Please ask for: Simon Algar  
Tel No: 01795 417375  
Our Ref: 18-506440-PAMEET  
Your Ref: -  
Date: 5<sup>th</sup> February 2019

**18/506440/PAMEET - Request for Pre-application planning advice - Derbies Barn, Stalisfield Road, Stalisfield - Proposed amendments to approved applications: Ref SW/01/0383 and SW/01/0384.**

Drawing Name  
**Detail sheet, Sections and Materials**

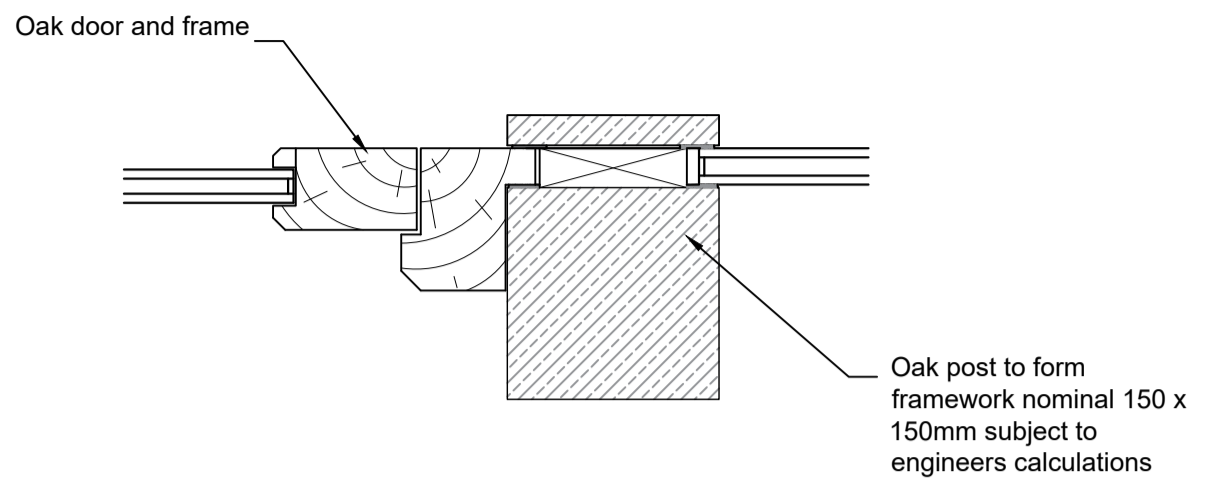
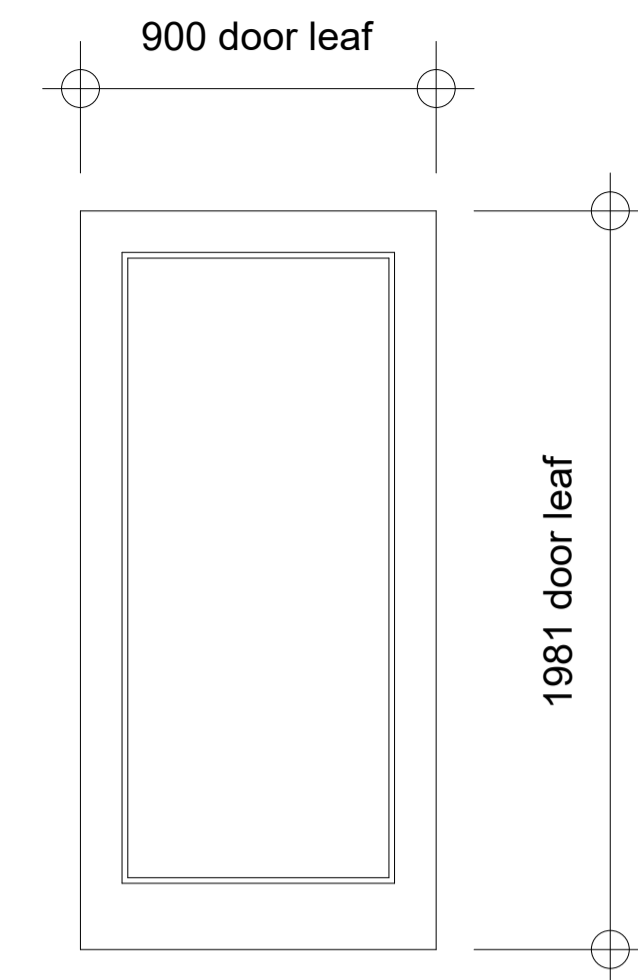
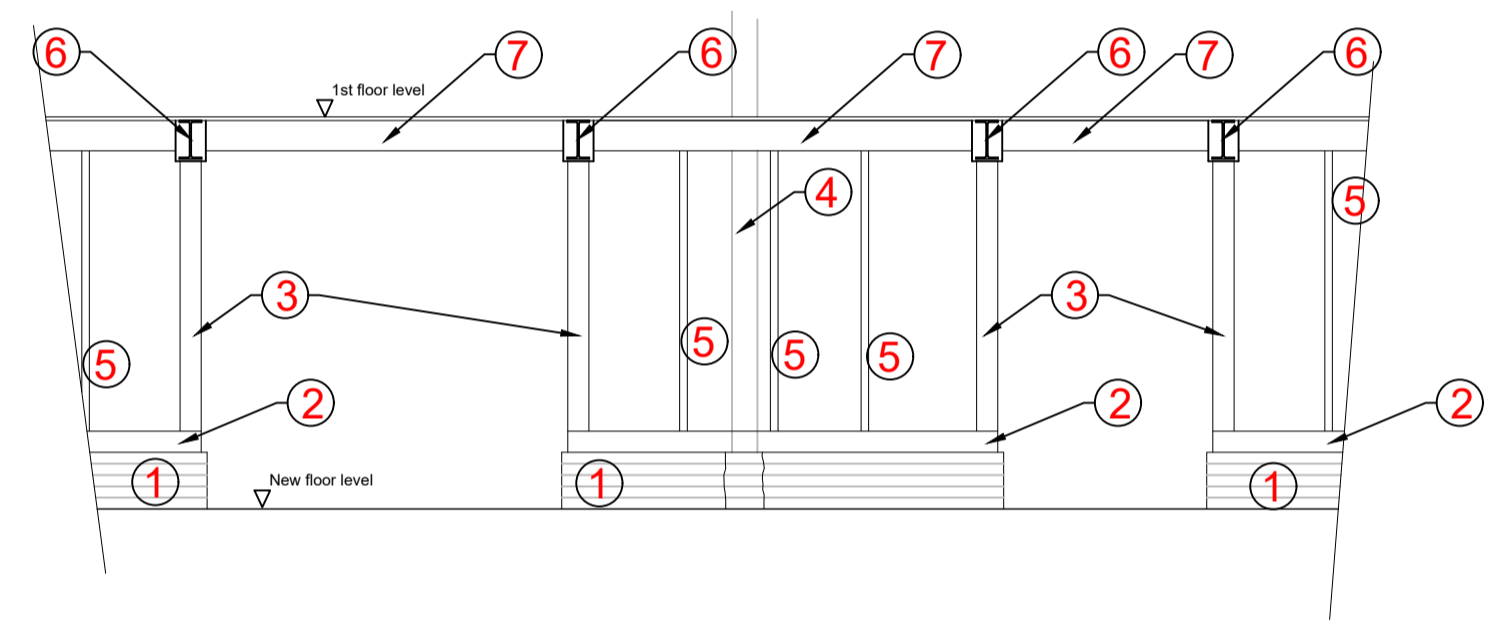
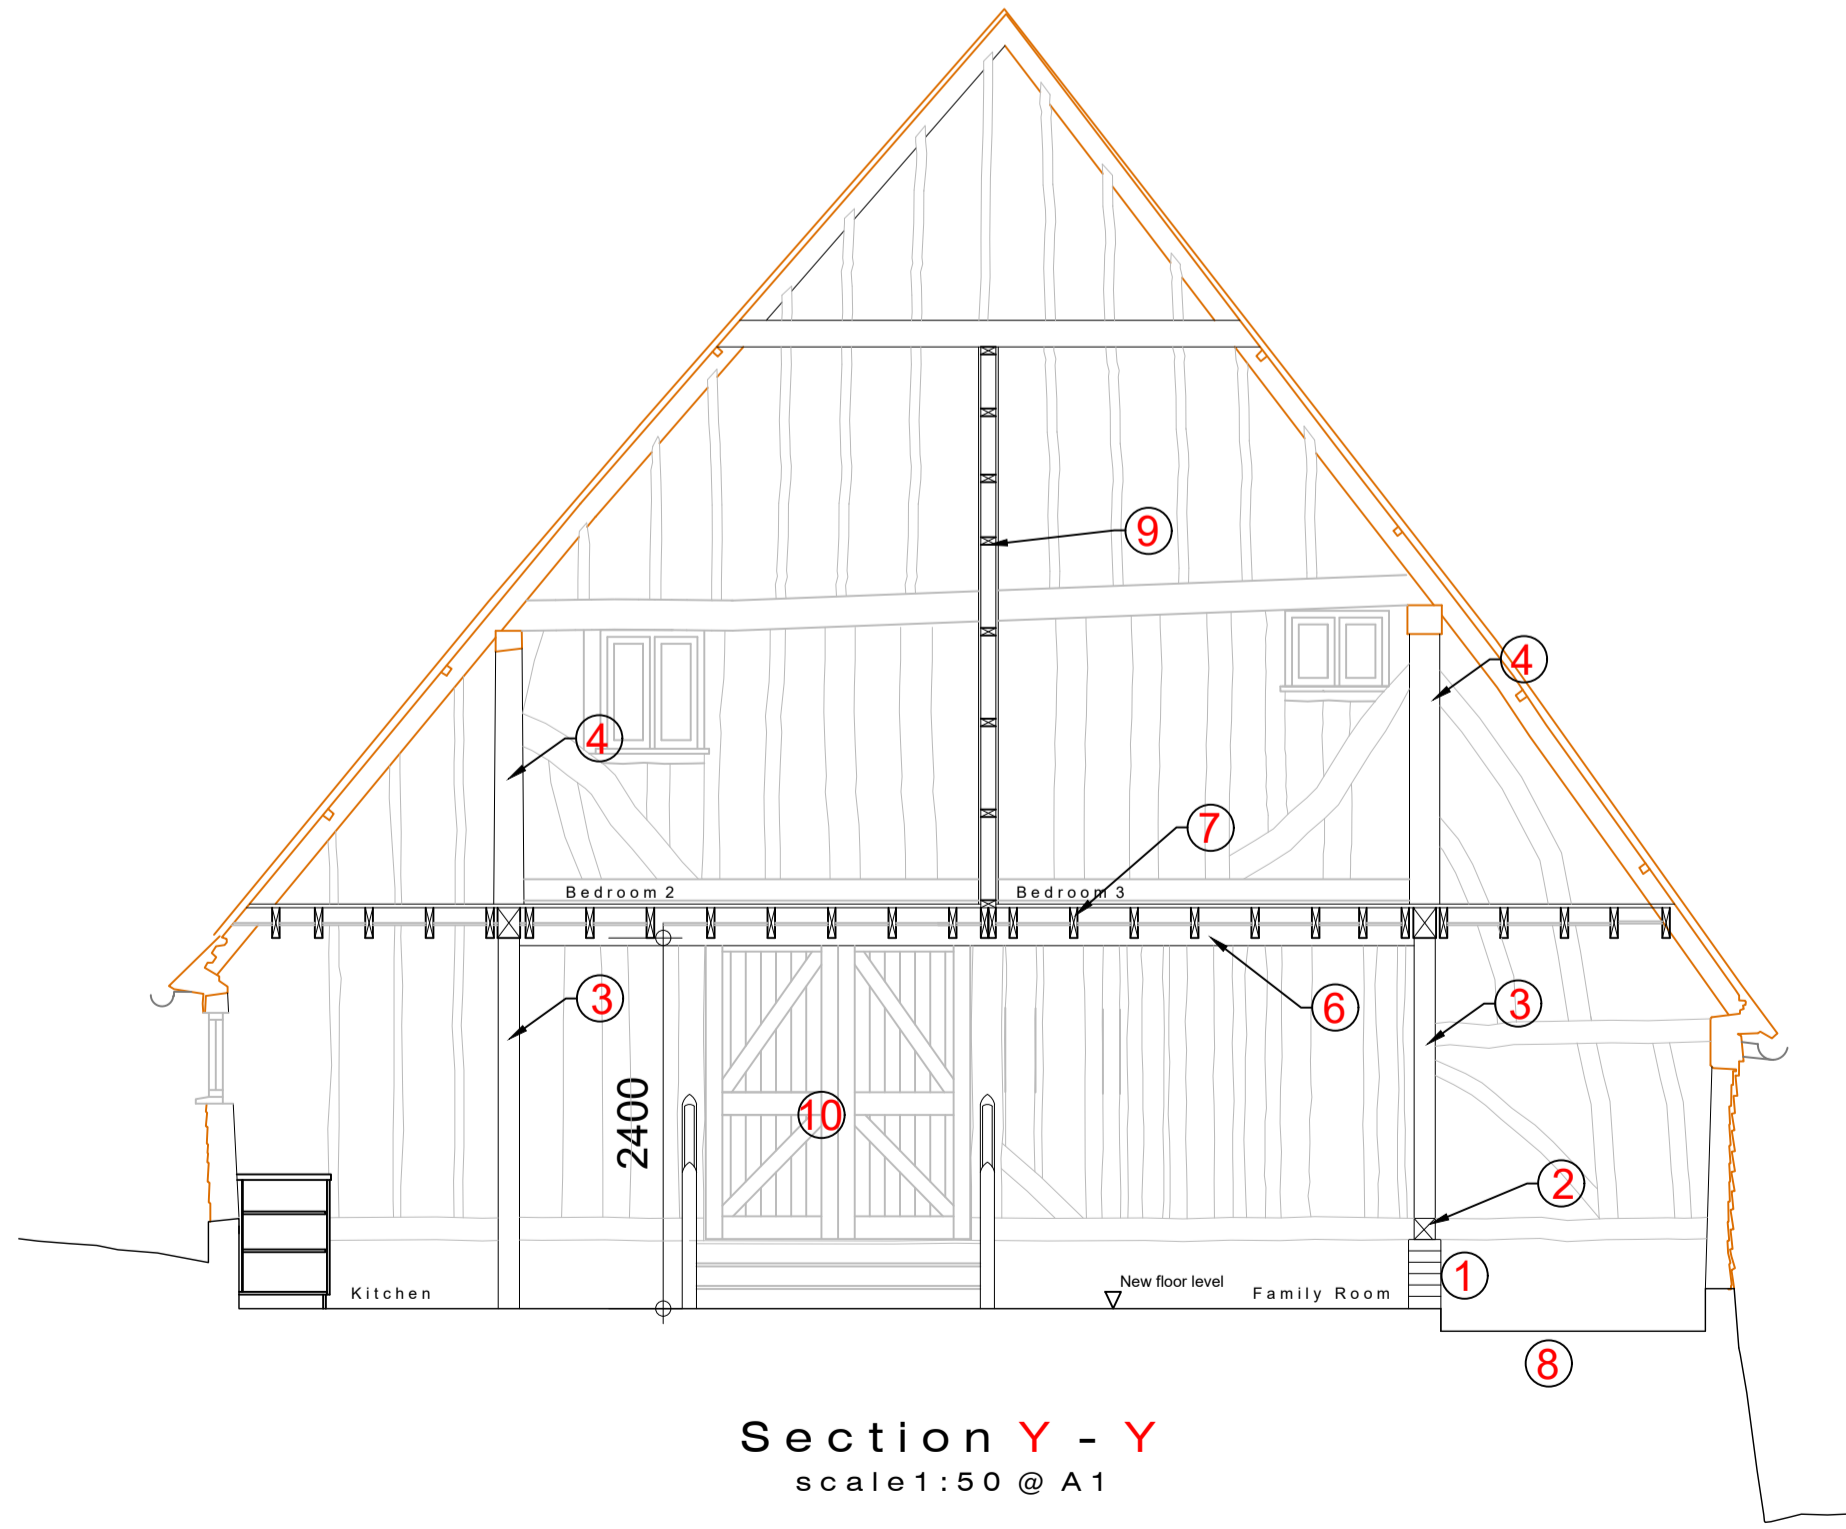
As discussed, the preference would be for this aspect of the previously scheme to remain unchanged. However The Council would be willing to consider the enclosing of this space if it can be done in a way that would be in keeping with the character of this later cart store addition to the larger and earlier main barn. As discussed, this might possibly be taken

forward in the form of timber studs set back behind the line of the existing corner and central support posts and their associated brackets. Double glazed panels could be inserted between the studs, and these and the associated glazing would need to sit on a shallow red brick and flint work plinth to match that in use at the far north western end of this single storey addition to the main barn. You would also need to demonstrate in the planning application that there is sufficient car parking and turning space for at least 2 cars.
